Our Ref: Y/19/20/RES

7th February 2020

Application for Approval of Reserved Matters Following Outline Approval

Location Land to the south of Ford Lane and east of North End Road Yapton

PROPOSED DEVELOPMENT PLAN

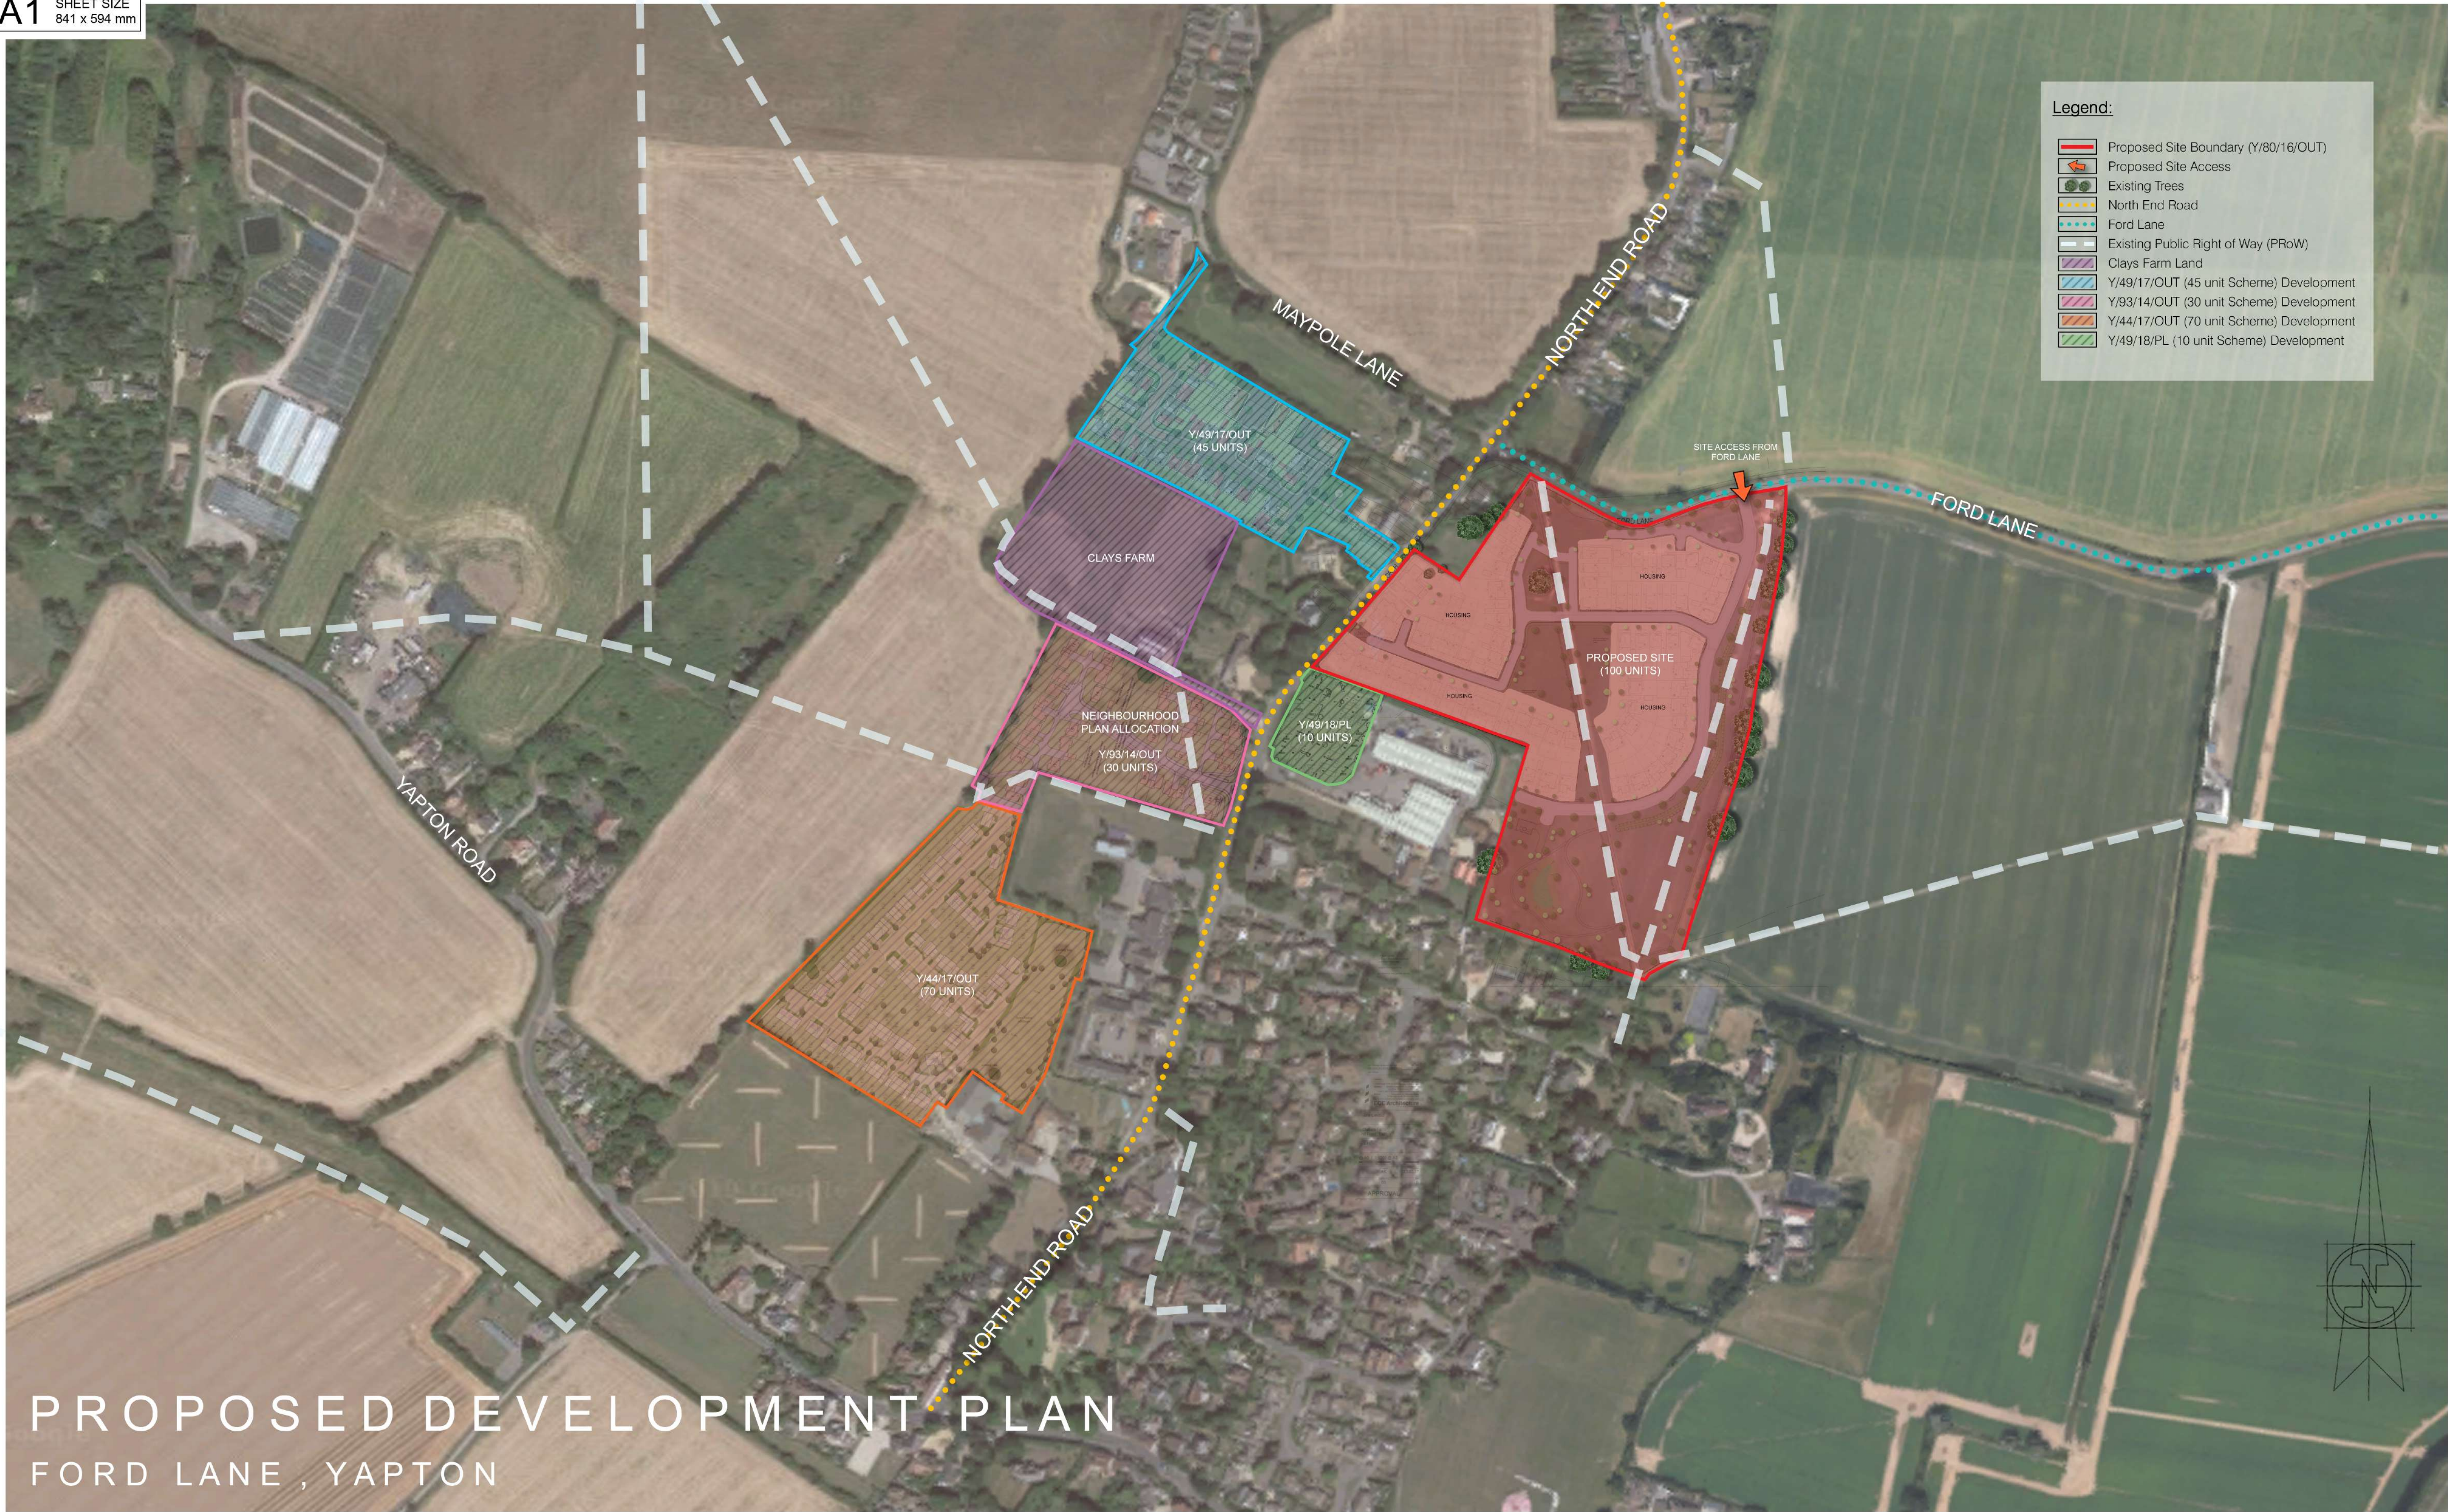
Please show the proposed pond on the Location plan, Massing plan, Occupancy plan, Parking plan, Affordable Housing plan, Planting Layout, Proposed Residential Development plan, Enclosure plan, Hard Surfacing plan, Refuse plan and Materials plan.

Section AA' scale 1:20 @ A2

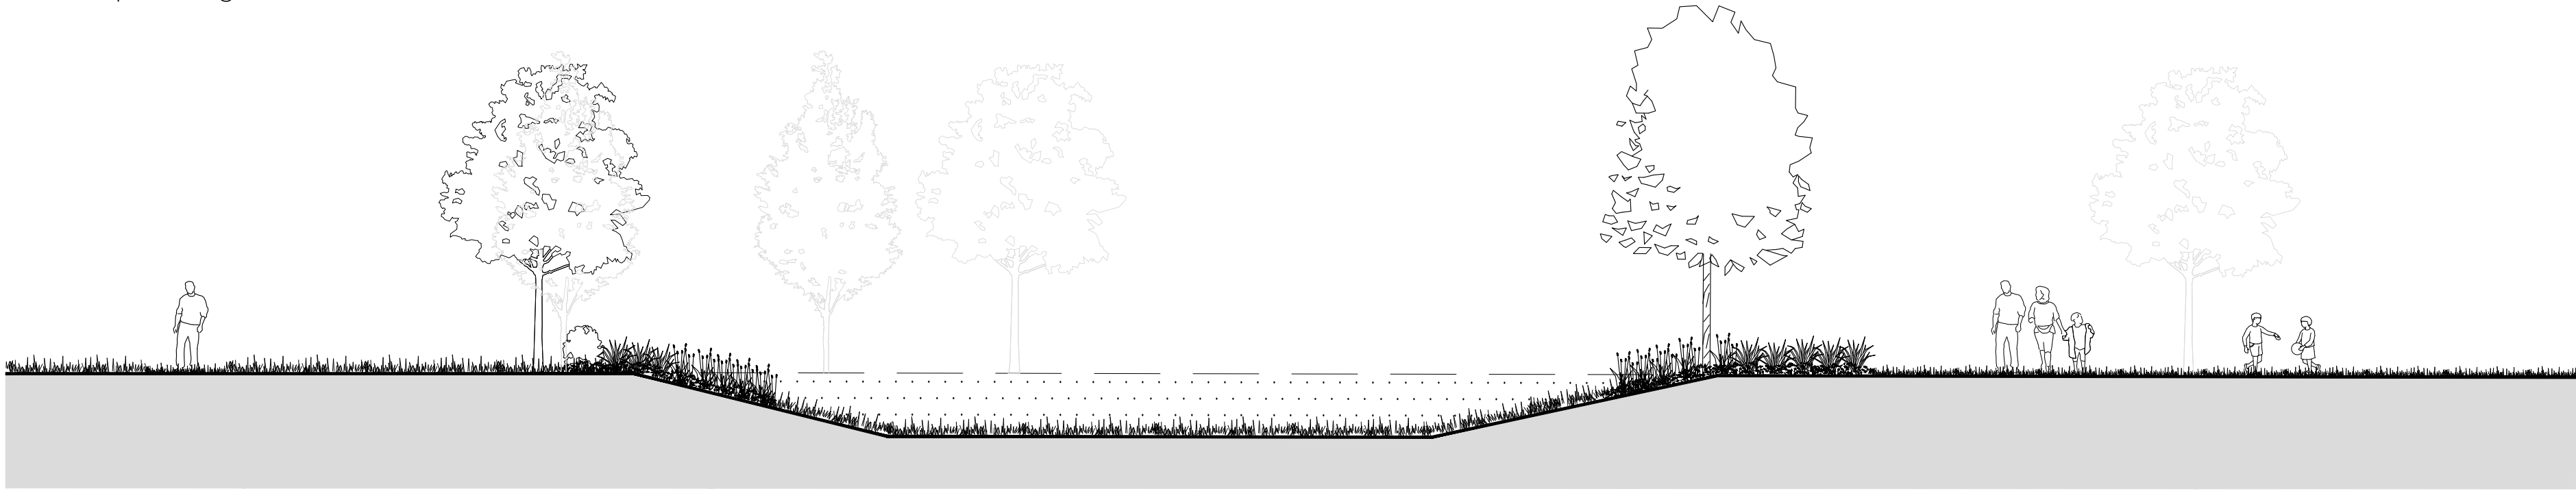
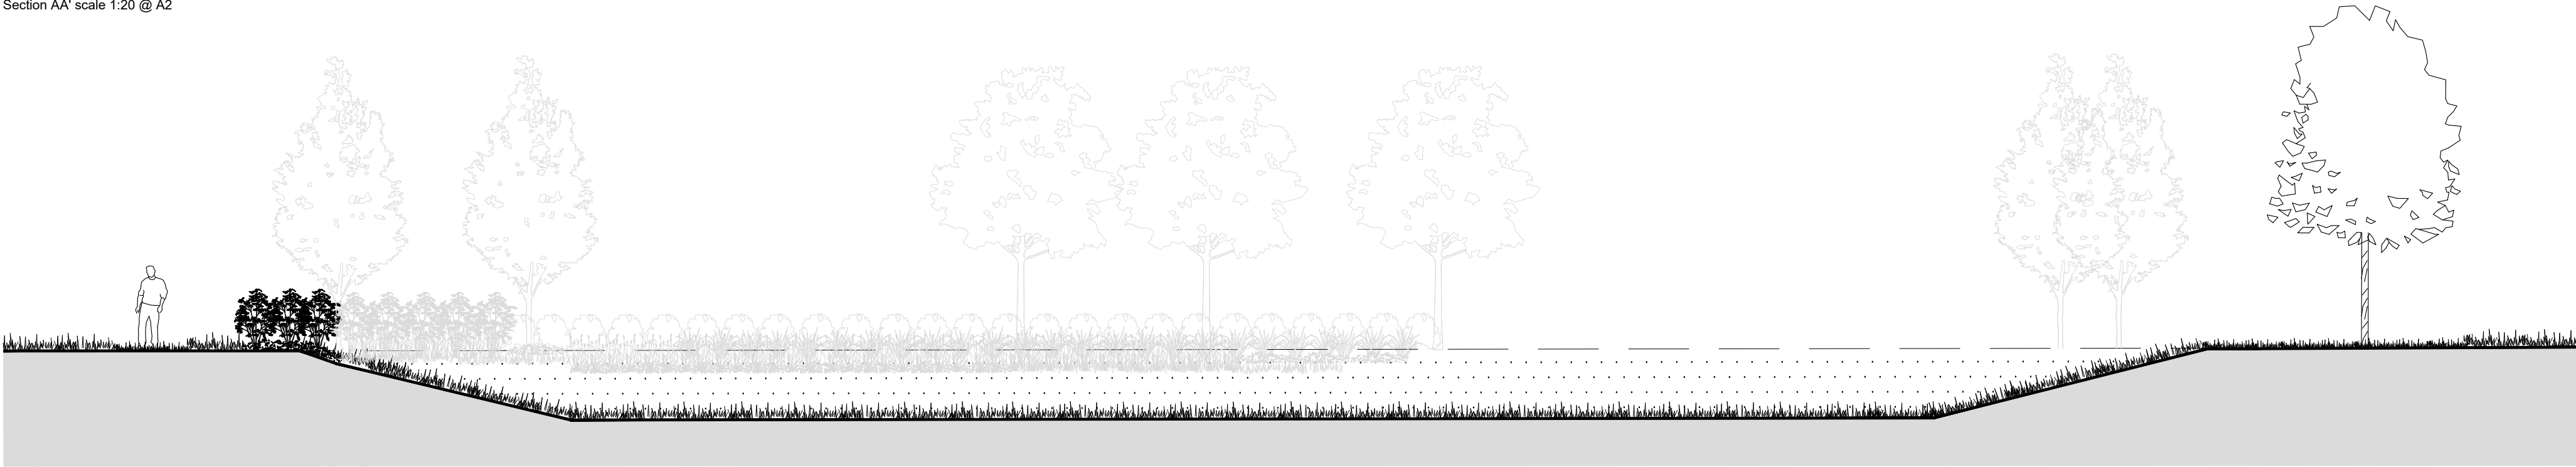
Please provide a section of the proposed pond.

Play Area (LEAP) - Scale 1:250@A1

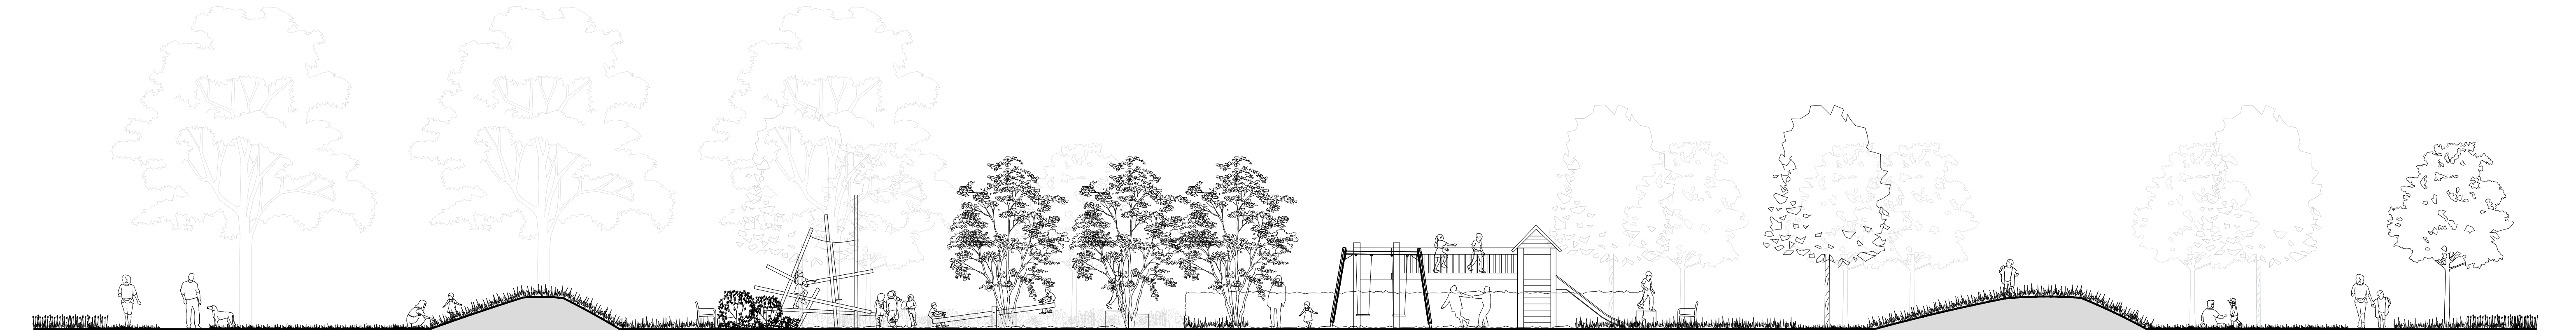
Please provide details of the LEAP areas.
